PCD FILE NO.: PPR2610

FOUNTAIN VALLEY SCHOOL
 ACADEMIC CENTER

SITE DEVELOPMENT PLAN

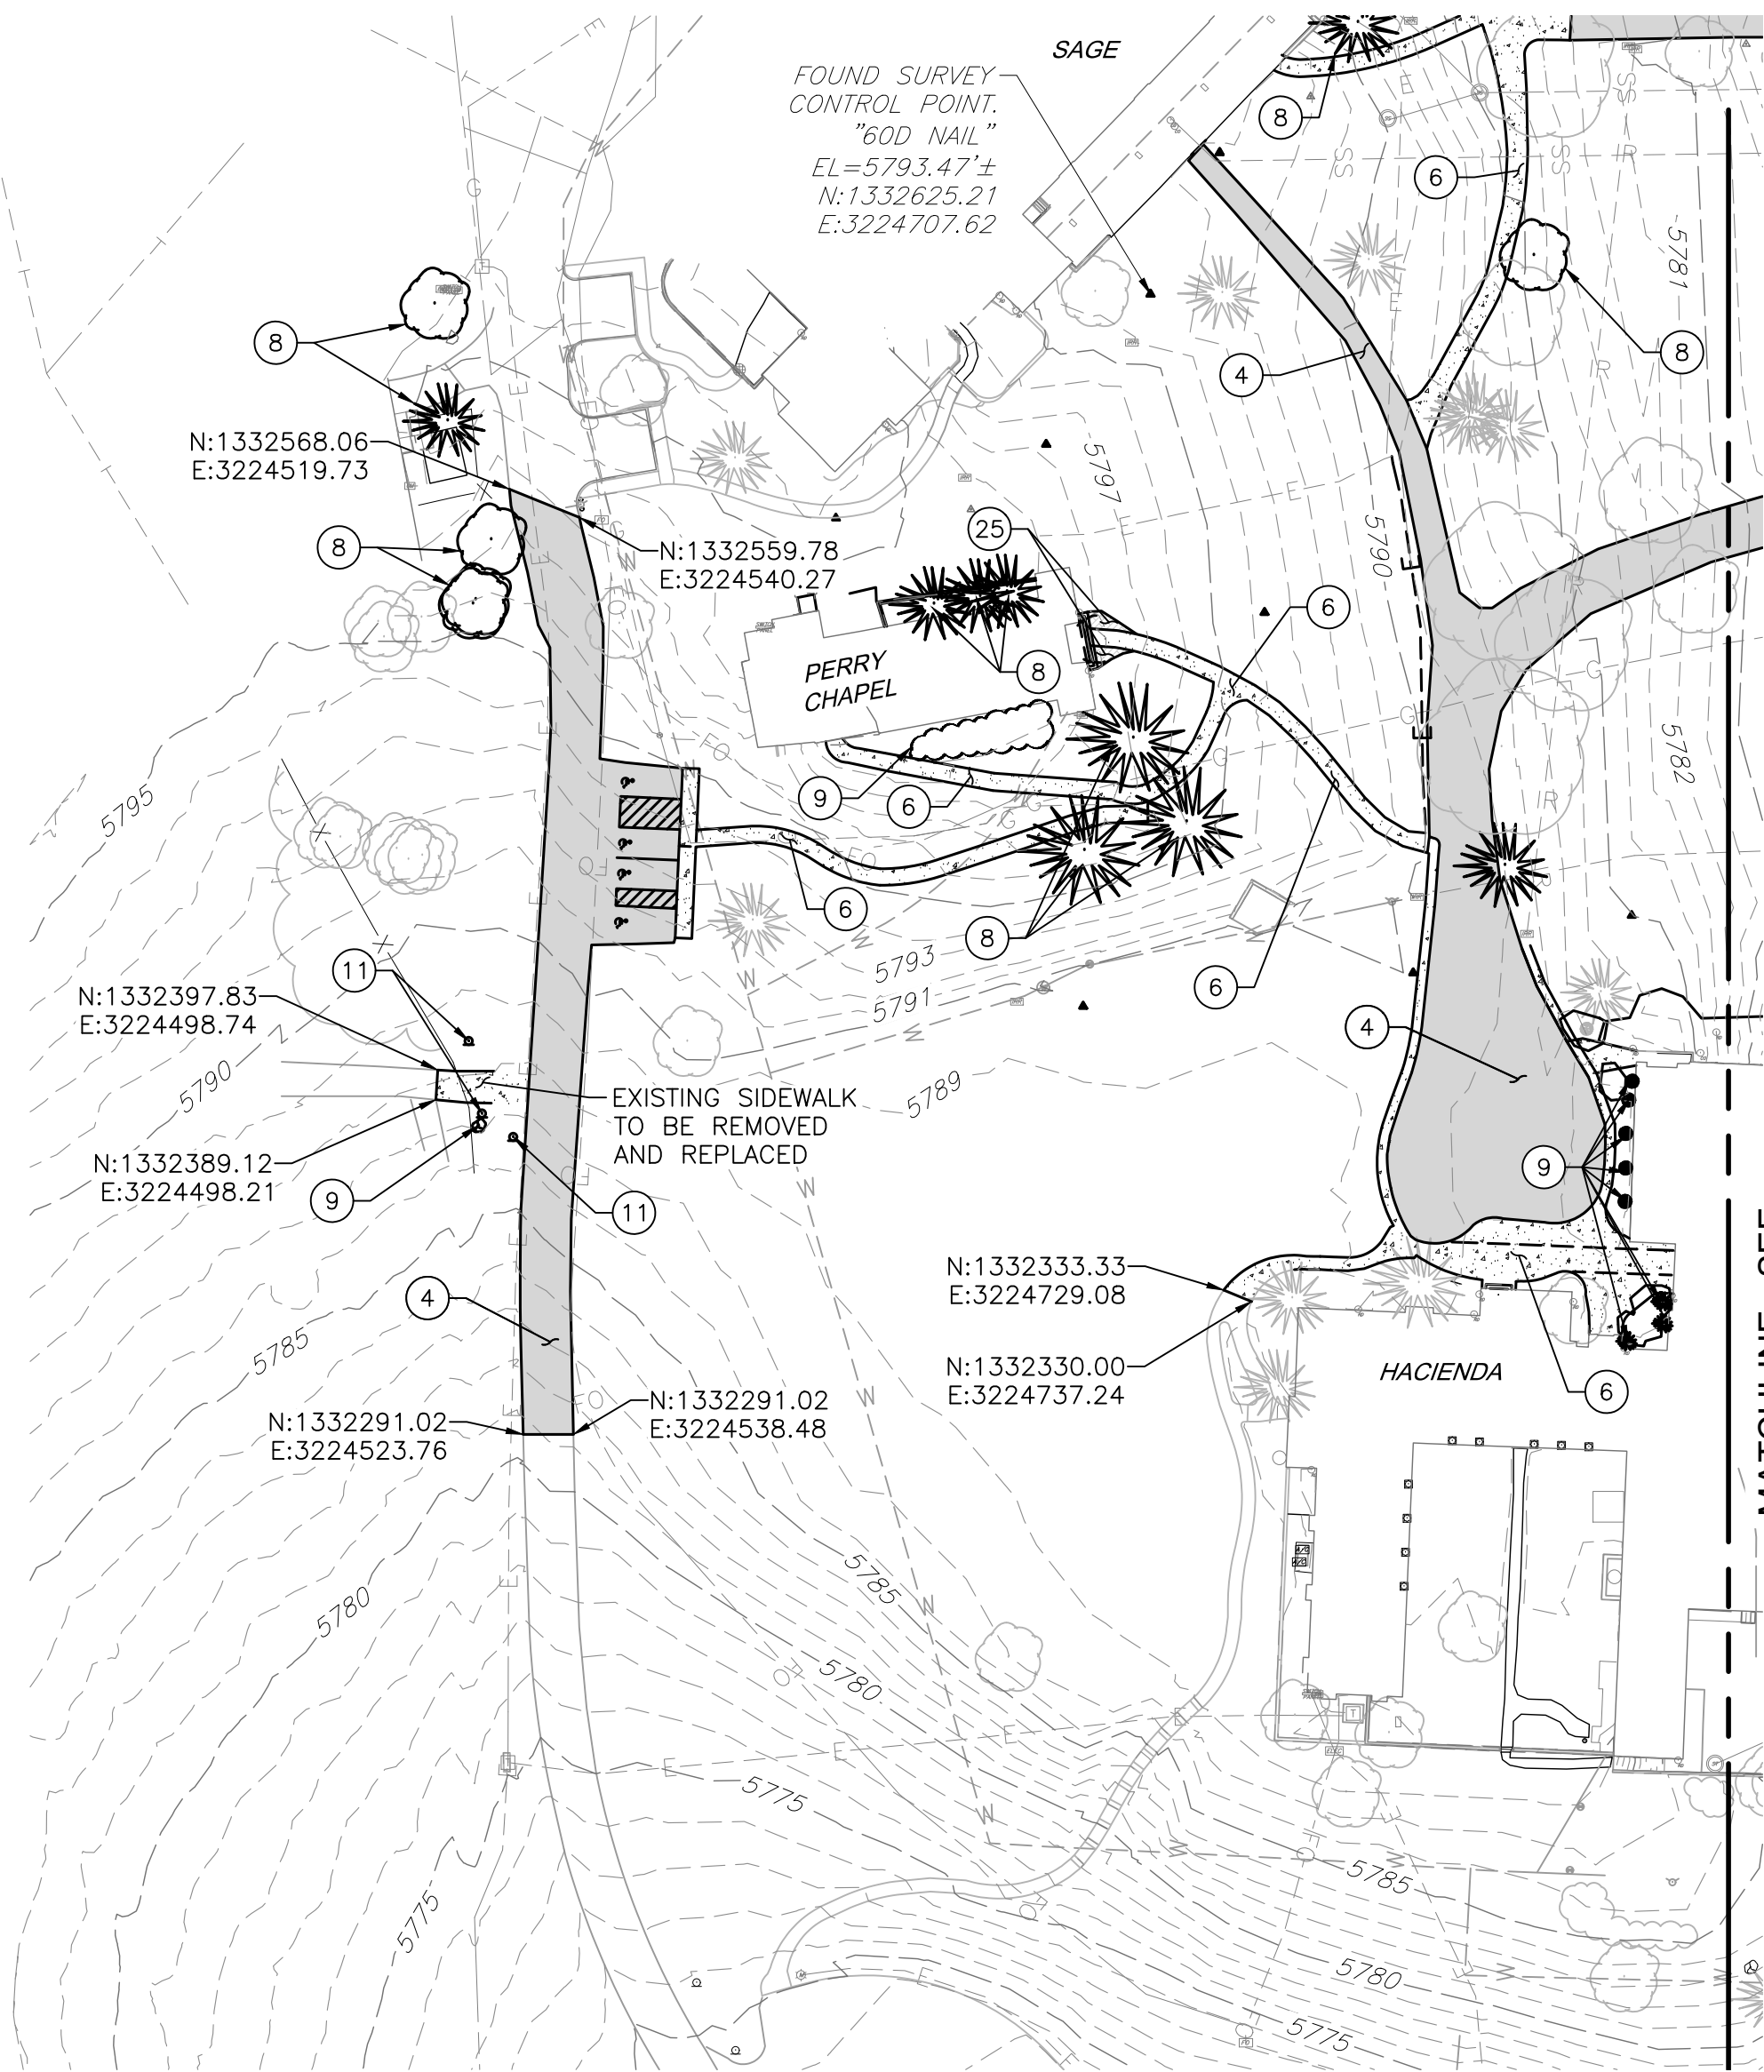
Provide a sheet showing the demo plan and what buildings are being removed. Include GSF of each building being demo'd

Please provide parking table, verification of parking space dimensional standards, ADA signage/stripping, and parking lot landscaping (islands) on a separate sheet.

Using this separate page to detail the traffic circulation in this area is highly encouraged. This will help address the Fire Protection District's comments and concerns.

For parking calculation, see EA Planning Checklist and LDC section 6.2.5.

If an alternative parking ratio or alternative design is requested, please specify and describe in the Letter of Intent.

Please include a legend.

Please identify the location of all garbage receptacles and the method of screening. (This can be provided on the Landscape Plan.)

Under the "Property Area" line, please add calculations for:
 % open space,
 % landscaped, and
 % impermeable surface.
 (Unless provided on the Landscape Plan.)

MM Response:
 Please refer to Letter of Intent for further detail on requested alternative parking ratio.

MM Response:
 Refer to Landscape plans.

MM Response:
 Demo plan with GSF of buildings being removed has been provided.

MM Response:
 Separate exhibits have been provided to SFPD for their review per a virtual meeting held with SFPD on 05/12/26

Please include a legend. **MM Response:** Legend has been added.

MM Response:
 Refer to Landscape plans.
